**Interim Submission**  
**Pending resolution of issues associated with access to the**  
**Bay and Basin Leisure Centre precinct**

**SHOALHAVEN CITY COUNCIL**  
**ENVIRONMENTAL ASSESSMENT SUBMISSION TO THE NSW DEPARTMENT**  
**OF PLANNING**  
**PART 3A, ENVIRONMENTAL PLANNING & ASSESSMENT ACT, 1979**

**MAJOR PROJECT APPLICATION MP 06\_0205**  
**Modification No 2**

**PROPOSAL:** Proposed MP06\_0205 VDC Stage 1 - Modification No 2 being modification to the VDC Stage 1 approval by delivery of the VDC is two stages with Stage 1 now being approx 22,600m<sup>2</sup> and the future Stage 2, being approx 9400m<sup>2</sup> floor area, and associated arrangements; and the delivery of various off-site works before occupation of the VDC Stage 1.

File Path: C:\DOCUMENTS AND SETTINGS\PETERS\MY DOCUMENTS\DRAWING.DWG  
June 30, 2009 7:45:46 am.

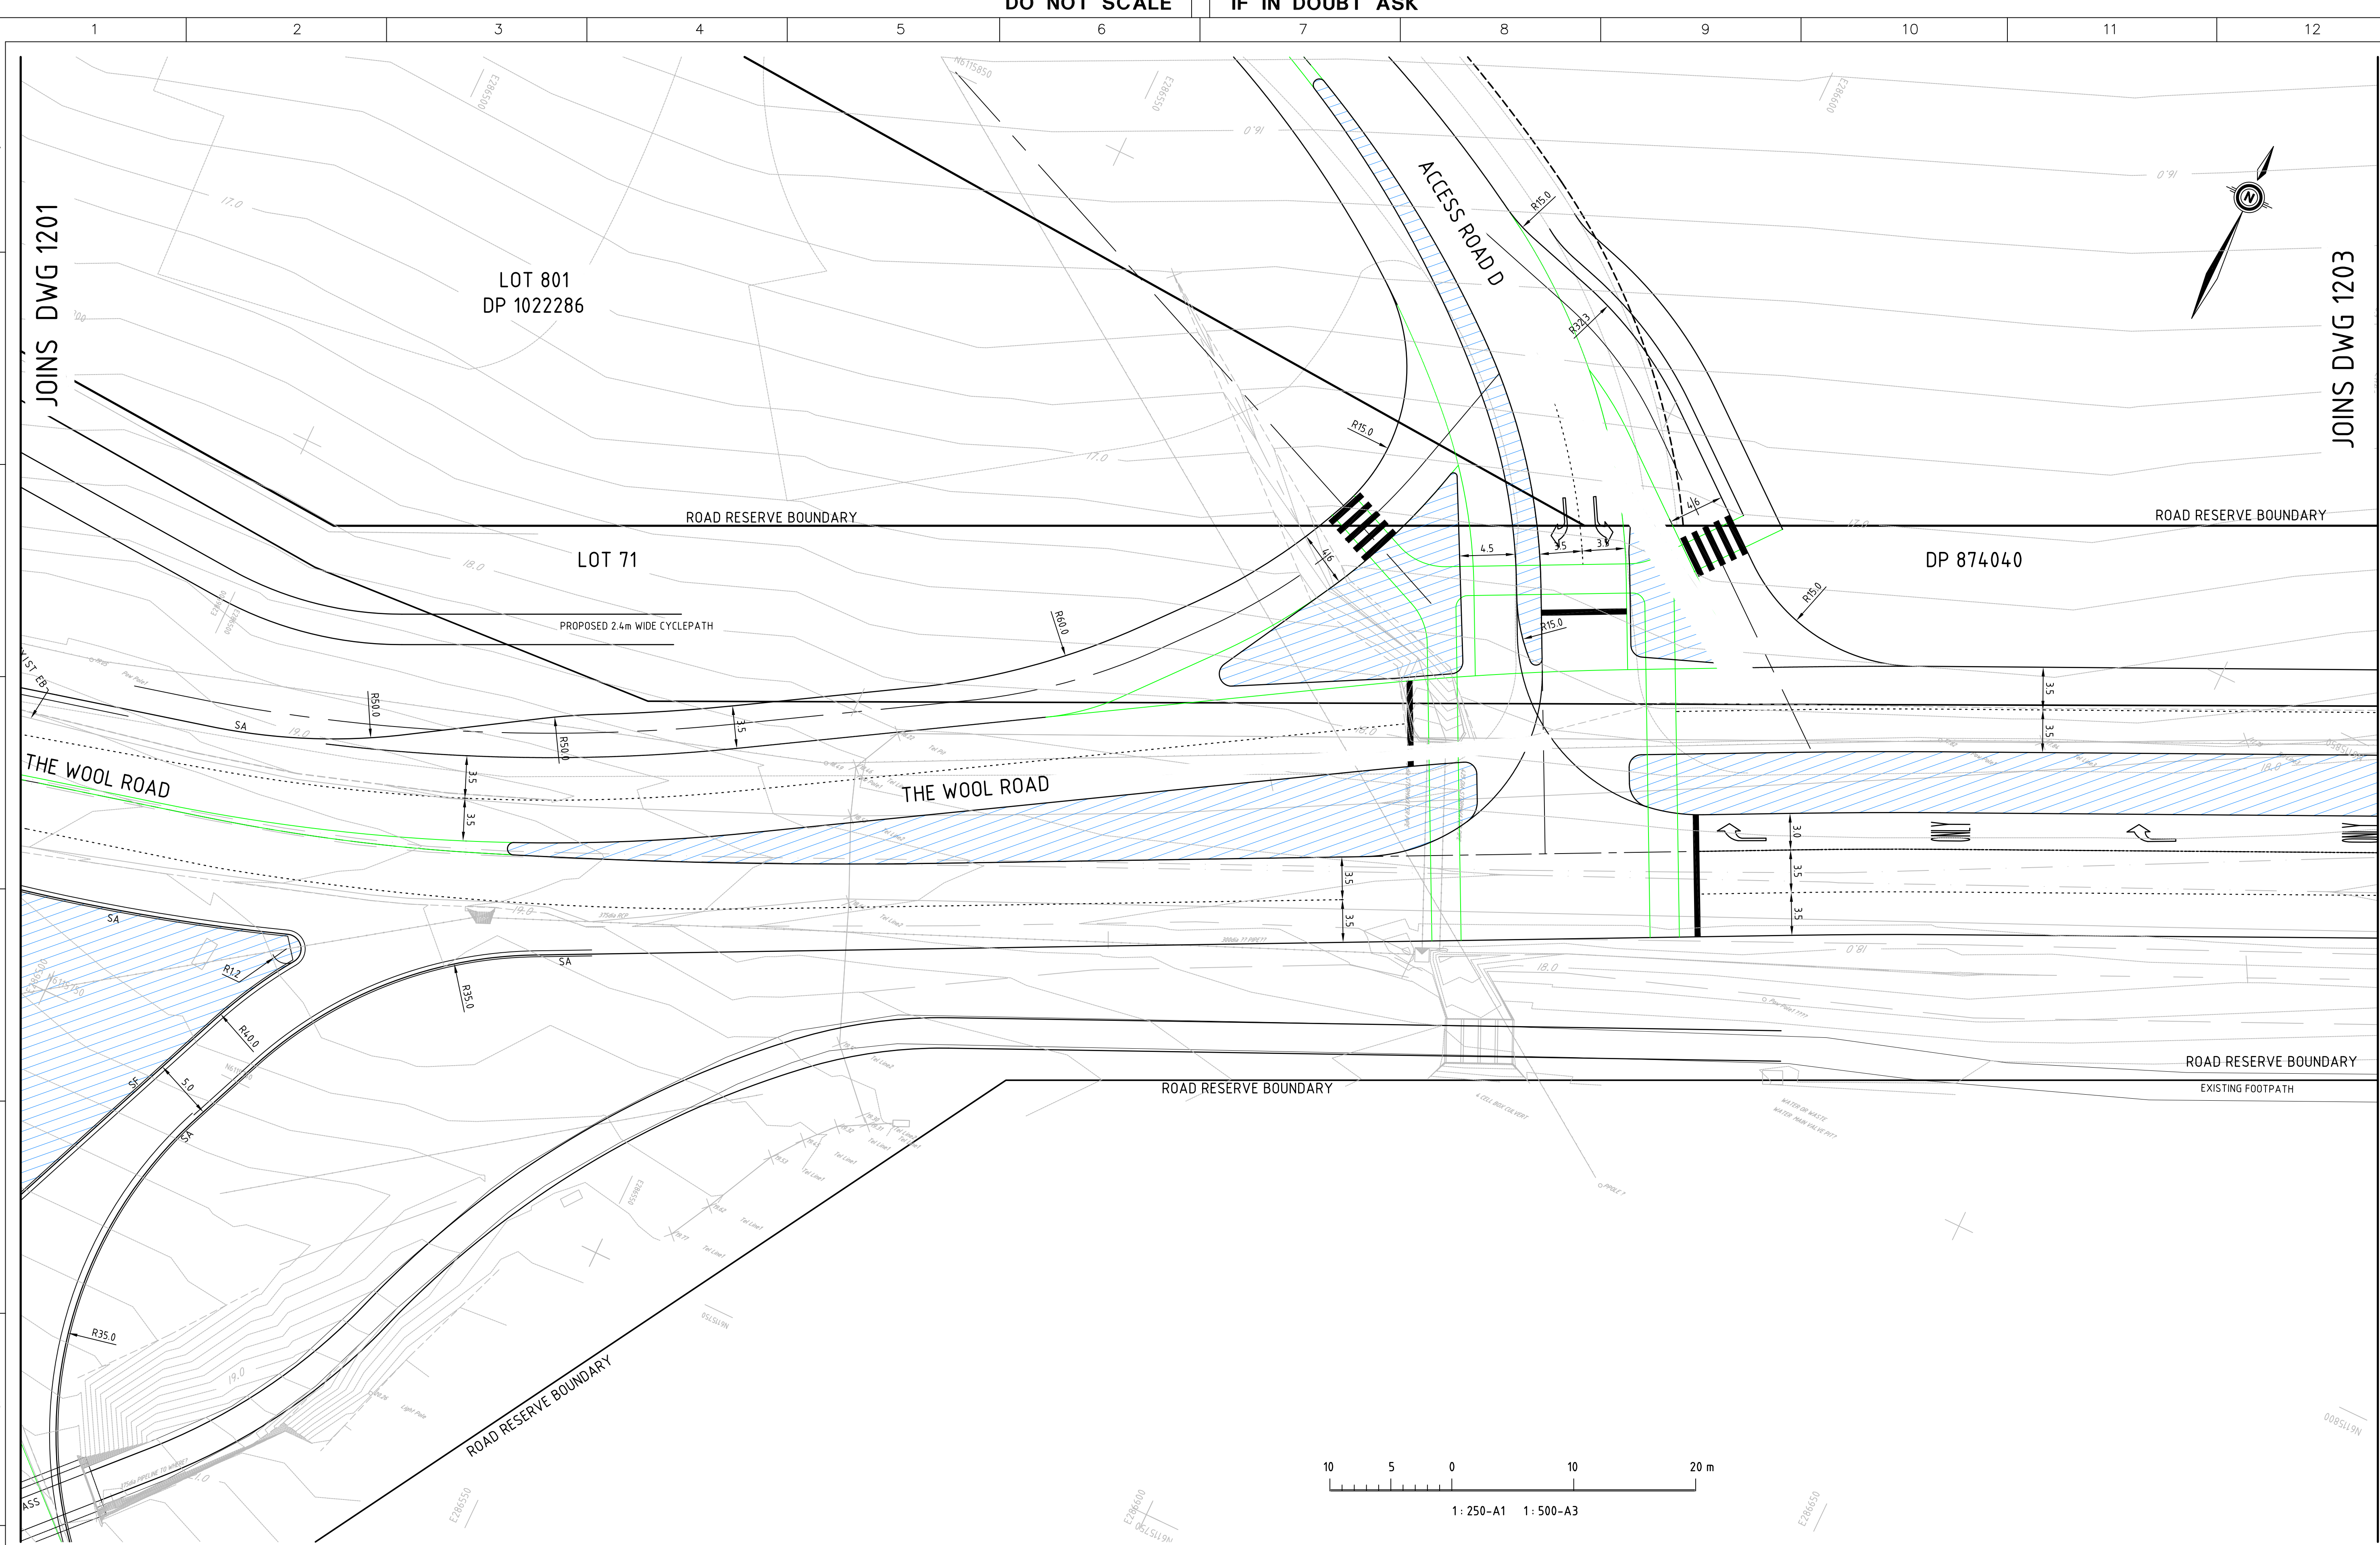
The design of a new road formation must take into account the constraints of the existing infrastructure in easements that exist and the final width necessary for two way movements and three lanes closer to the Wool Road ( similar to Cardno drawing 1010) will determine the reserve configuration. Council has provided comments on preliminary road designs that will be the subject of future consideration and referral to the Roads and Traffic Authority before determination and approvals are issued.
